Submission – Warragamba Dam Raising Project – SSI8441

**William Dixon,
Springwood NSW
In the role of Chair,
Regional Advisory Committee,
National Parks and Wildlife Service,
Blue Mountains Branch**

The Regional Advisory Committee, NPWS Blue Mountains Branch objects to the proposal to raise the wall of Warragamba Dam for the temporary detention of flood water.

Figure 8-4. Upstream impact area

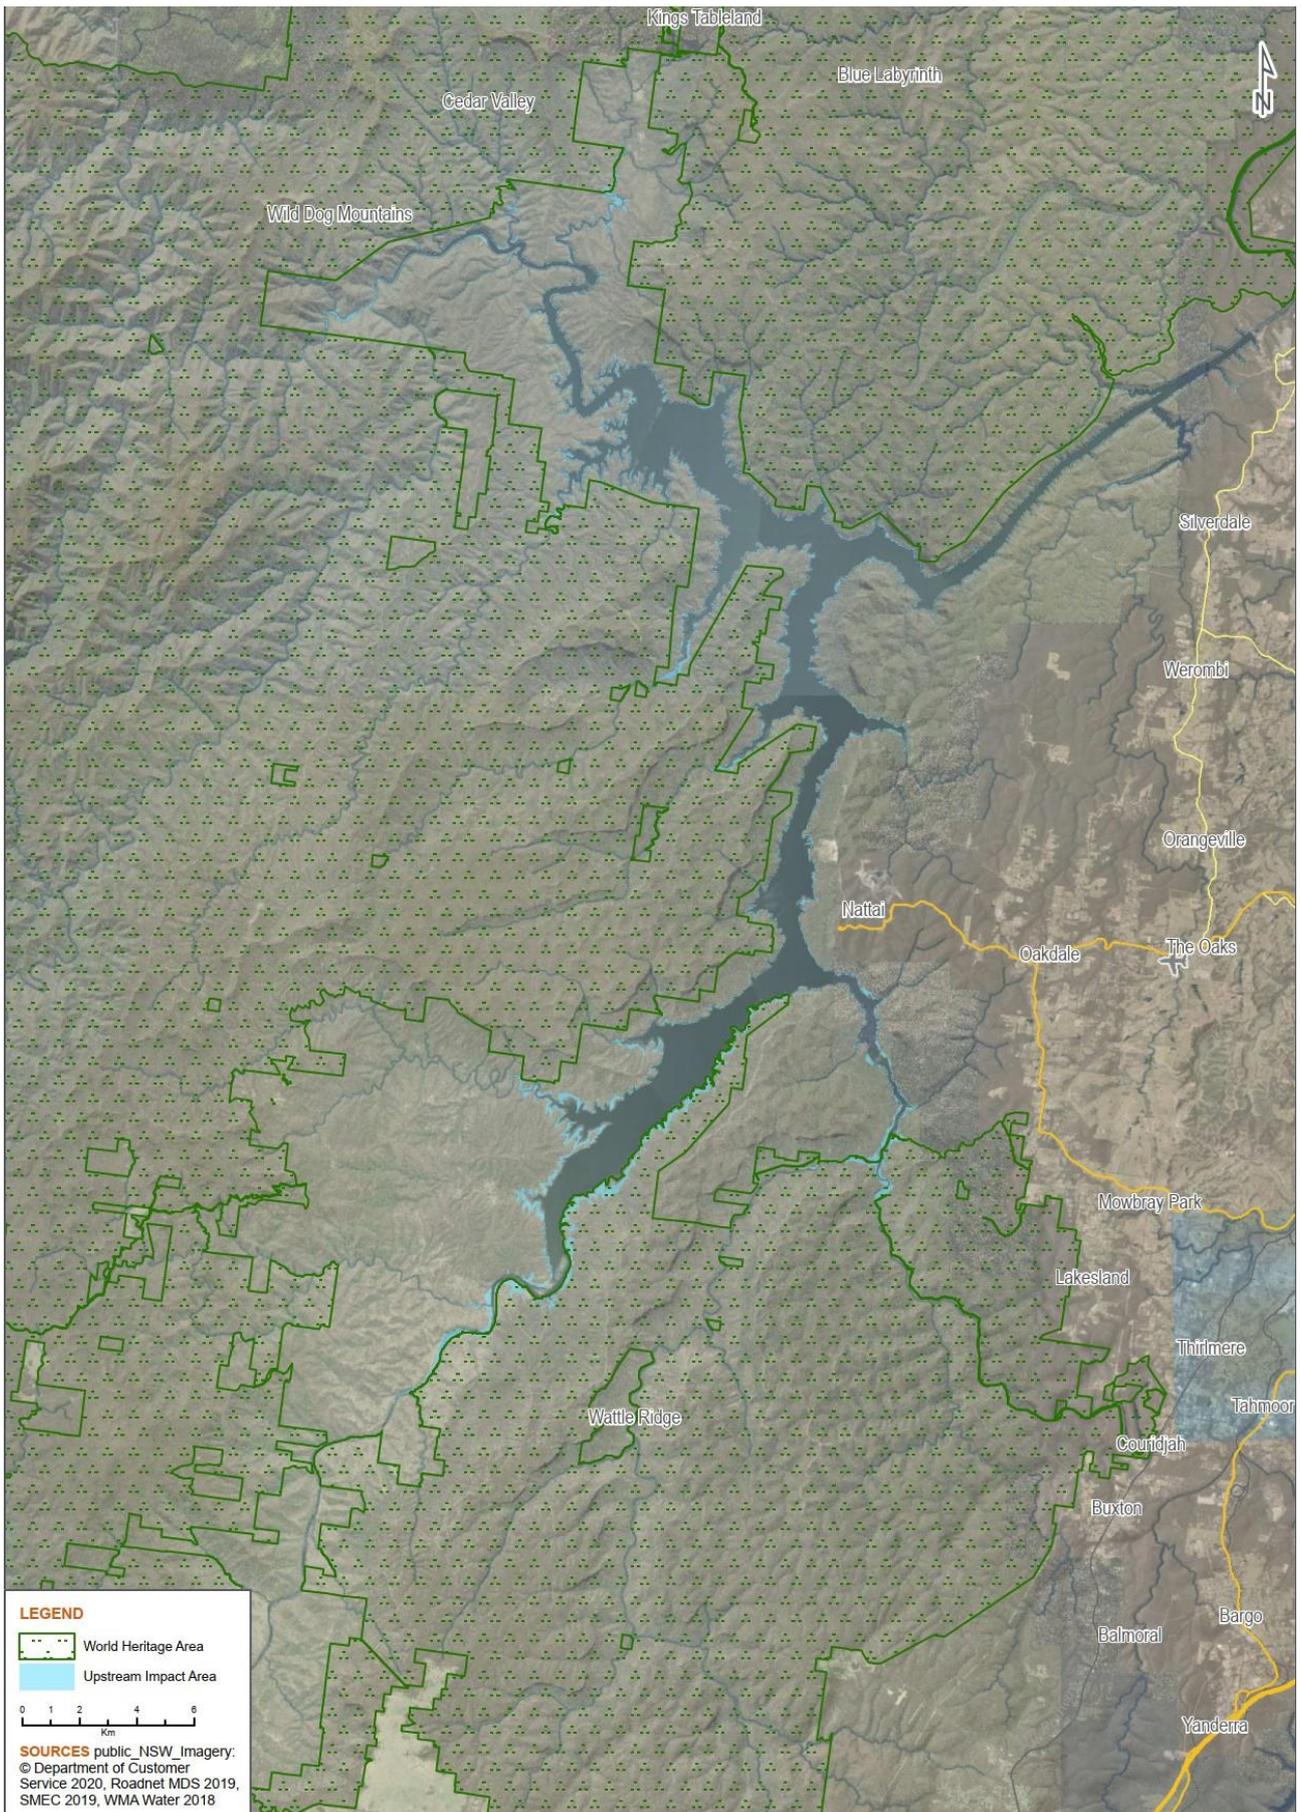
The *Upstream Impact Area* as the “likely inundation area”, defined as the area inundated at 2.78 to 10.25m above the FSL. The area of the upstream impact area is about 1400 hectares with 304 hectares occurring within the GBMWA

The EIS states “since the construction of Warragamba Dam, the “likely inundation area” is the maximum level achieved”. However, this is

- A short time period on which to base an assessment as 60 years is insignificant in geological time
- The EIS elsewhere considers risk of significantly higher rainfall due to climate change.

- The auxiliary spillway was built based on the risk of a 1 in 1000 flood.

This is creative accounting to minimise the impact area to reduce the cost of biodiversity offsets.

Conducting 20,000 Monte Carlo simulated events may sound rigorous, but it is of limited value because it is based on the single arbitrary assumption that the impact is related only to the increase in flooding associated with average maximum floods in 20-year periods.

If 20,000 Monte Carlo events were simulated to determine the increase in average maximum inundation in 100-year periods, a different impact area would be derived. Although there would be overlap, it would cover an area beyond the 1400 hectares derived from the 20-year analysis.

Realistically, the impact area should be calculated on the area inundated by the water level at the “full” level when the wall is raised 14m. This is expected as the wall is not being raised 10.25 m (the “likely” event described) but 14 m with the provision for an additional 3 m for future contingencies.

In addition, the EIS discounts the impact zone by stating there are already areas inundated when the dam exceeds 100% capacity. This is used to exclude the FSL to 2.78 m above the current dam wall height from the impact area.

If the area currently intermittently flooded when the dam exceeds 100% capacity is removed from the calculations, there should be an additional area of impact added above the FSL of the additional 14 m of detention for events that exceed FSL. This is clearly anticipated by the fact that the construction will include the abutments so that an additional 3 m of detention can be added.

Figure 20-9. Area of potential additional inundation of the GBMWHA for the upstream impact area

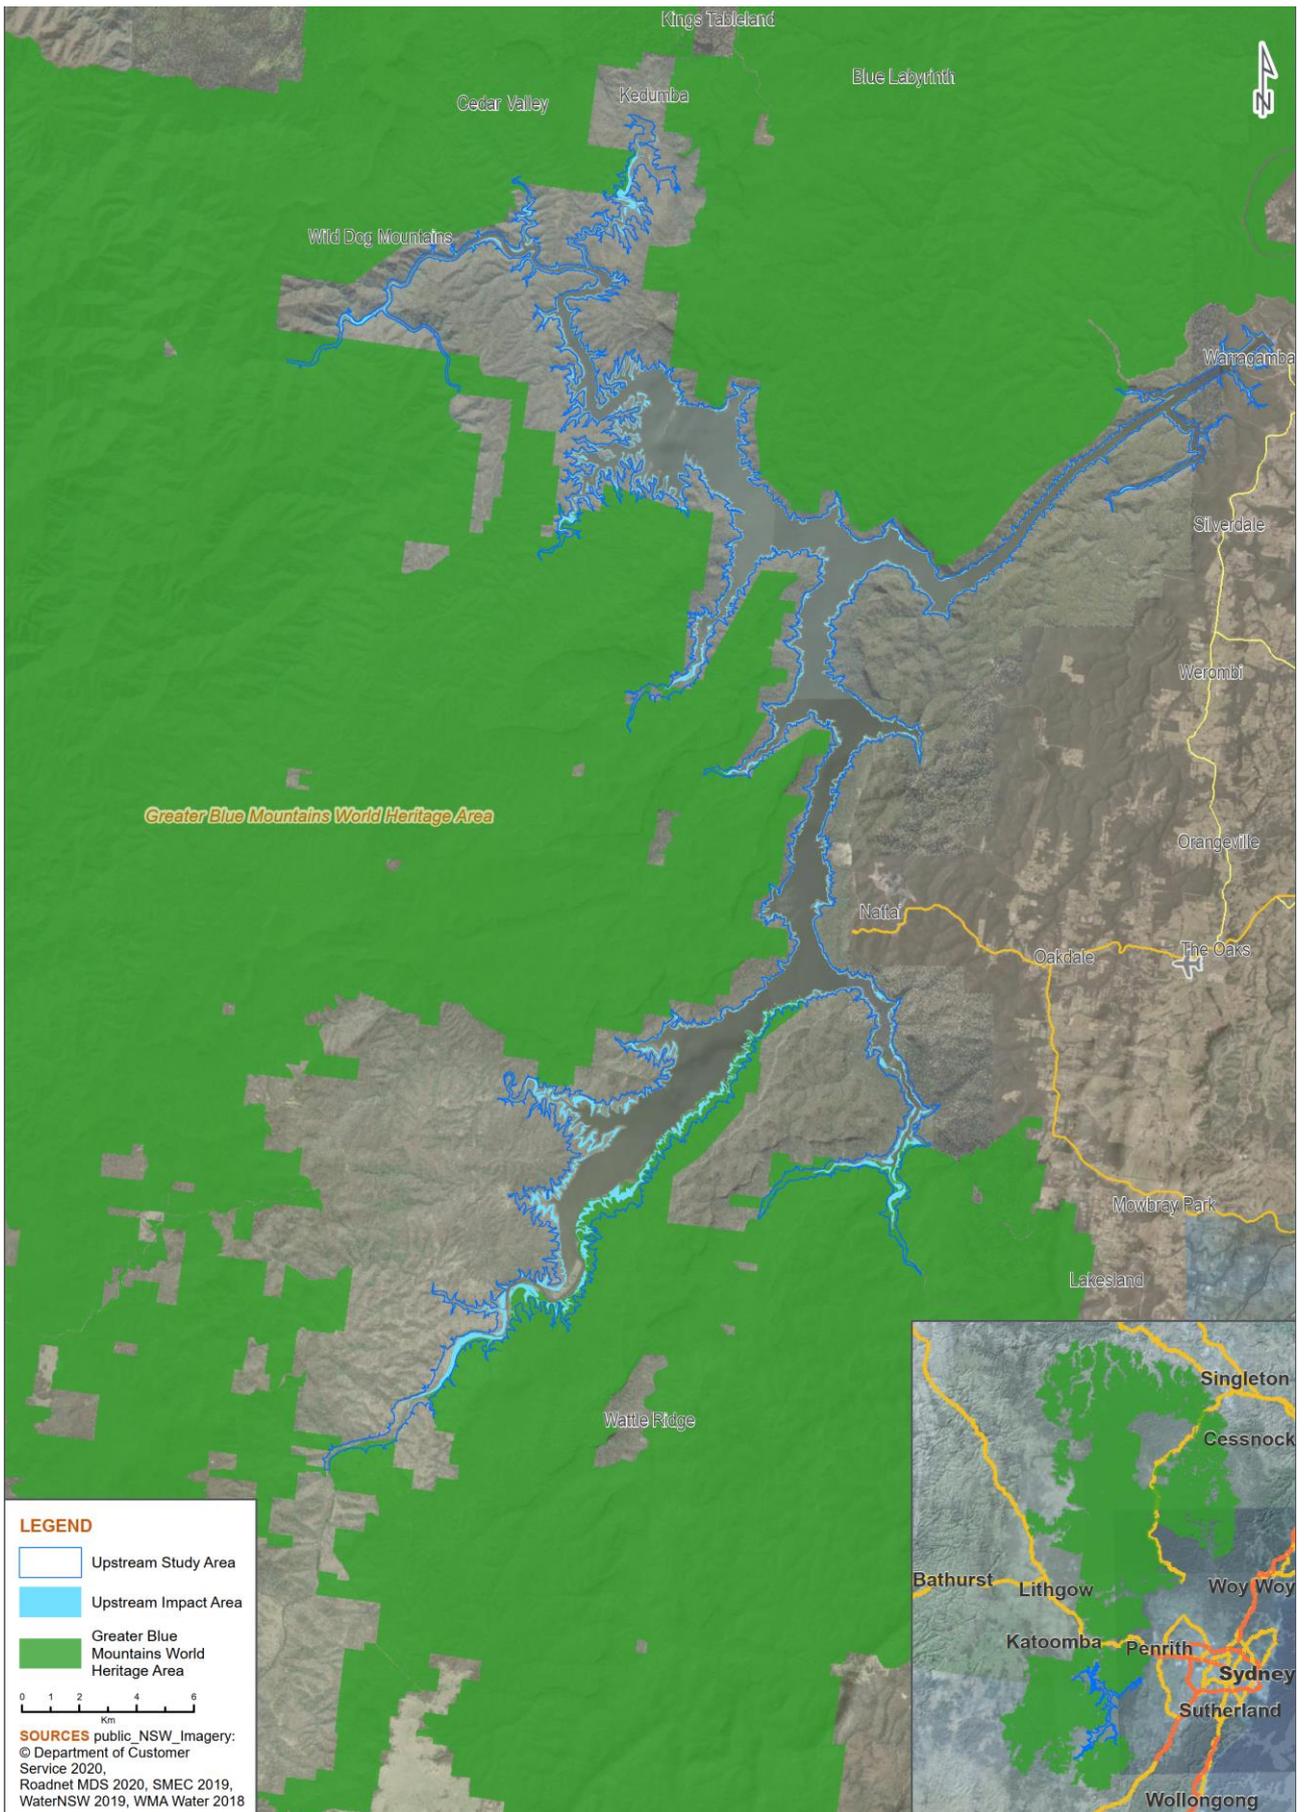
The EIS calculates the area of “likely impact area” to be about 1400 ha with 304 ha occurring within the GBMWHA (0.03%). The inadequacies of the use of the “likely impact area” have already been discussed.

It must be recognised that the reserve outside the boundary of the WHA also contributes to the OUV. The World Heritage Area is reviewed periodically and boundaries may change based on the current assessments.

Thus, the impact of raising the dam wall is far greater than acknowledged in the EIS, as a result of underreporting the area of impact and the impact on reserved areas outside the WHA boundary that contribute to the OUV of the GBMWHA.
